**WELWYN HATFIELD BOROUGH COUNCIL
EXECUTIVE DIRECTOR - PLANNING, PUBLIC PROTECTION AND GOVERNANCE**

Application No: 6/2020/1872/LAWP
Location: 89 Lemsford Road Hatfield AL10 0DZ
Proposal: Certificate of lawfulness for hip to gable and dormer roof extensions.
Officer: Mr Tom Gabriel

6/2020/1872/LAWP

PROPOSED SOUTH ELEVATION

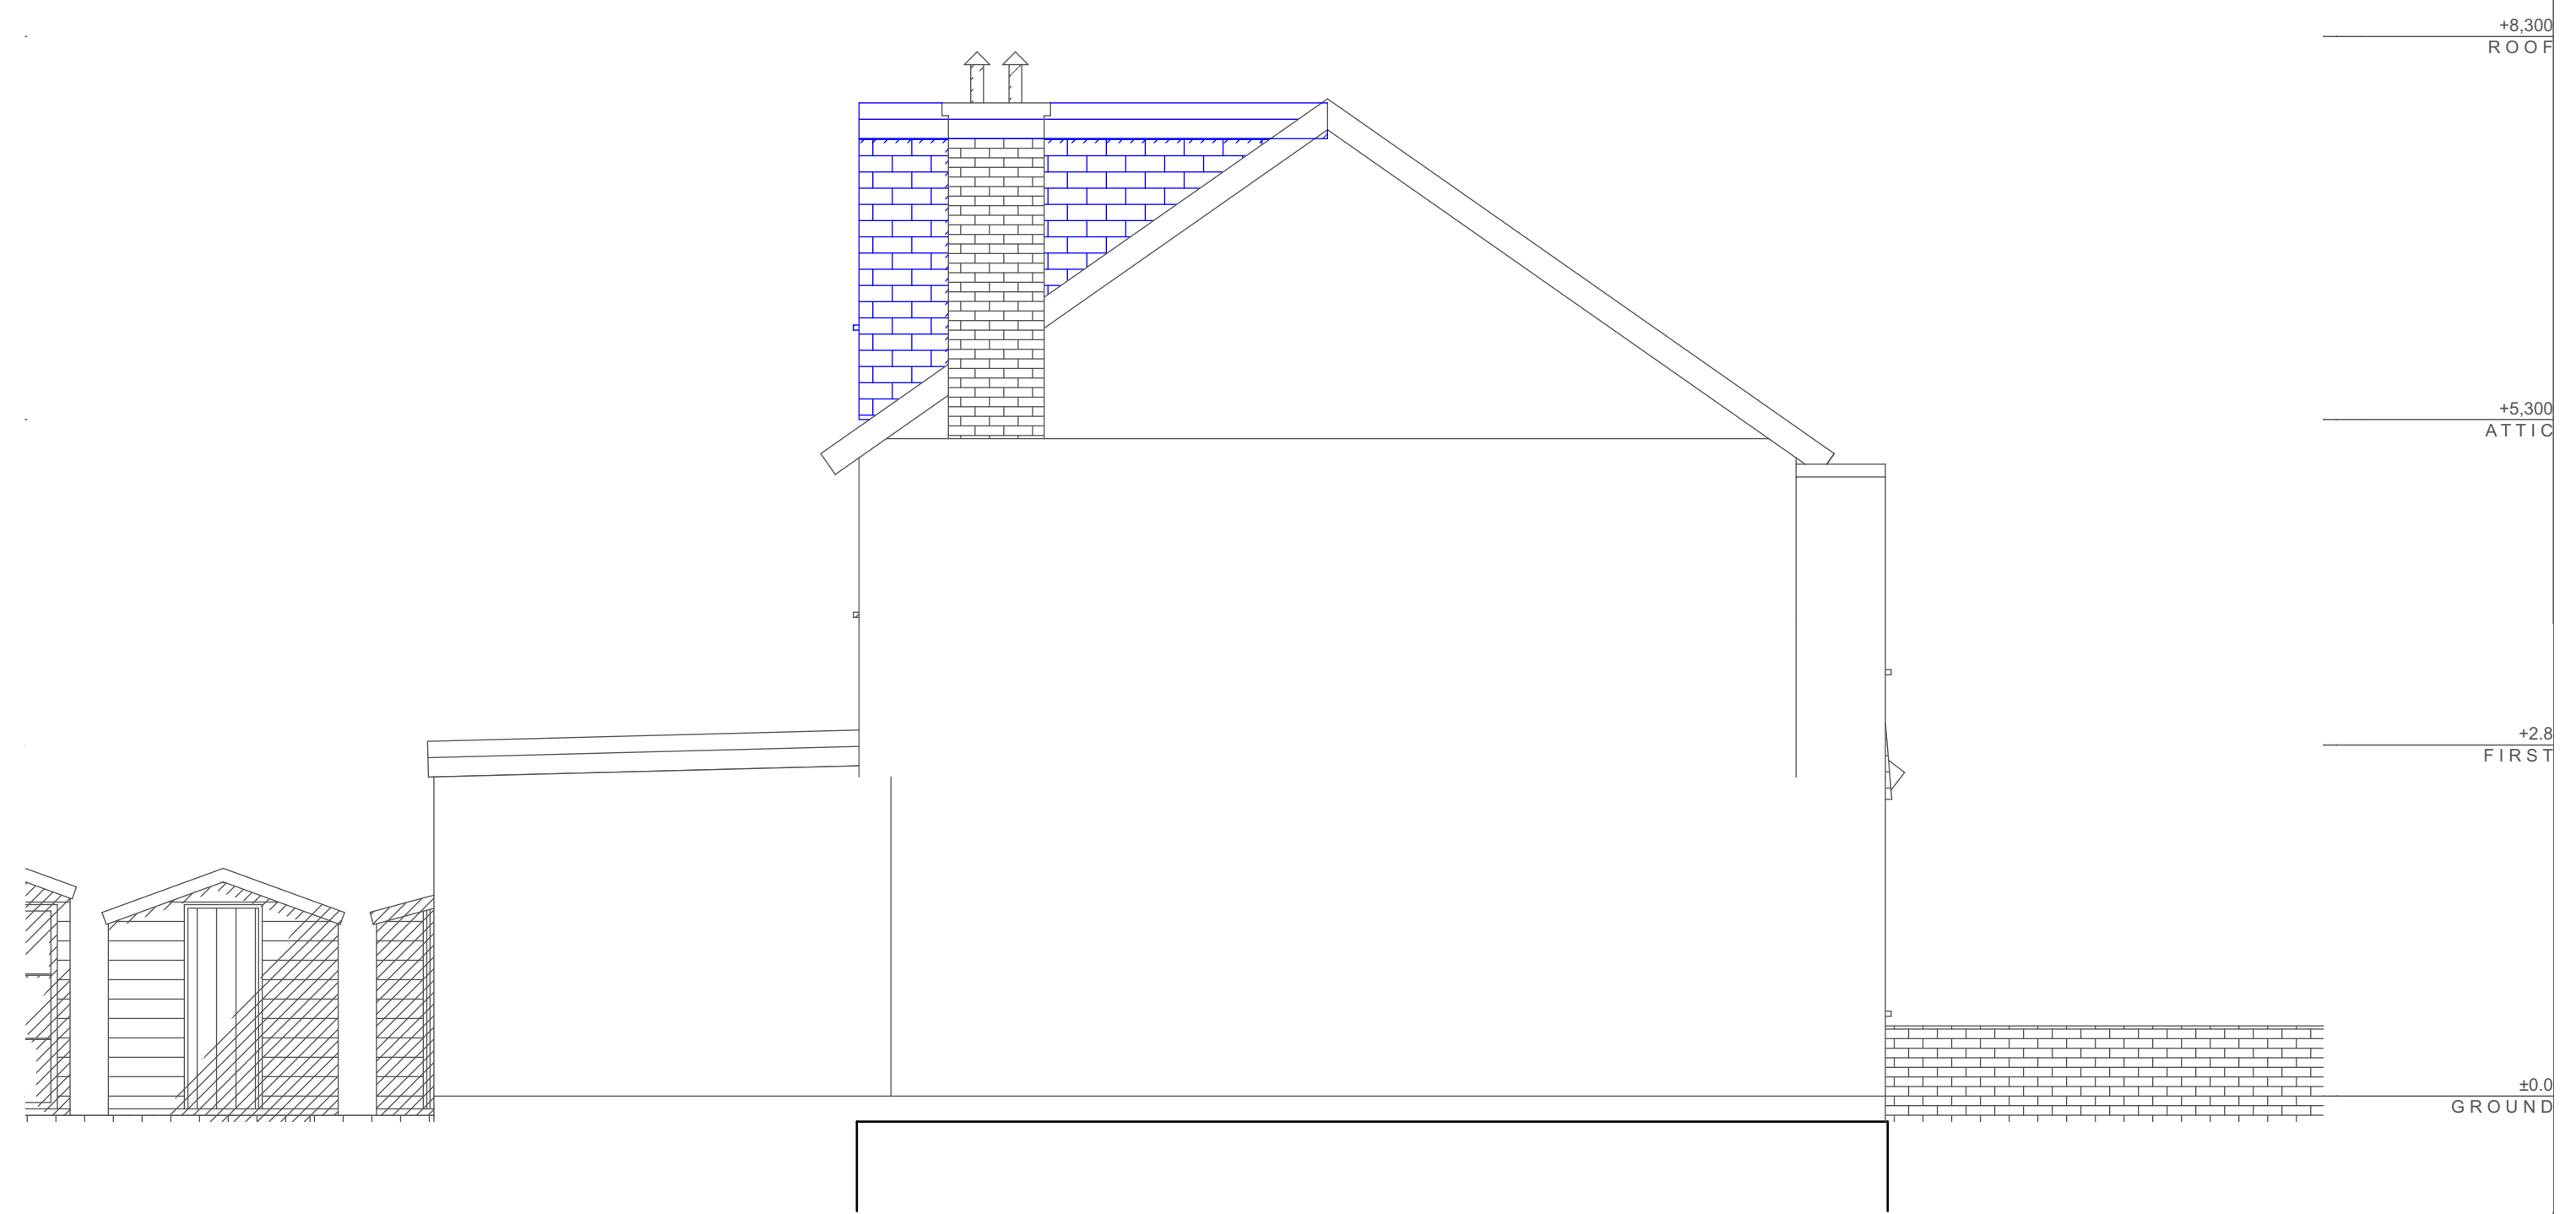
| (b) would any part of the dwellinghouse, as a result of the works, exceed the height of the highest part of the existing roof | N | N |

| (c) would any part of the dwellinghouse, as a result of the works, extend beyond the plane of any existing roof slope which forms the principal elevation of the dwellinghouse and fronts a highway | N | N |
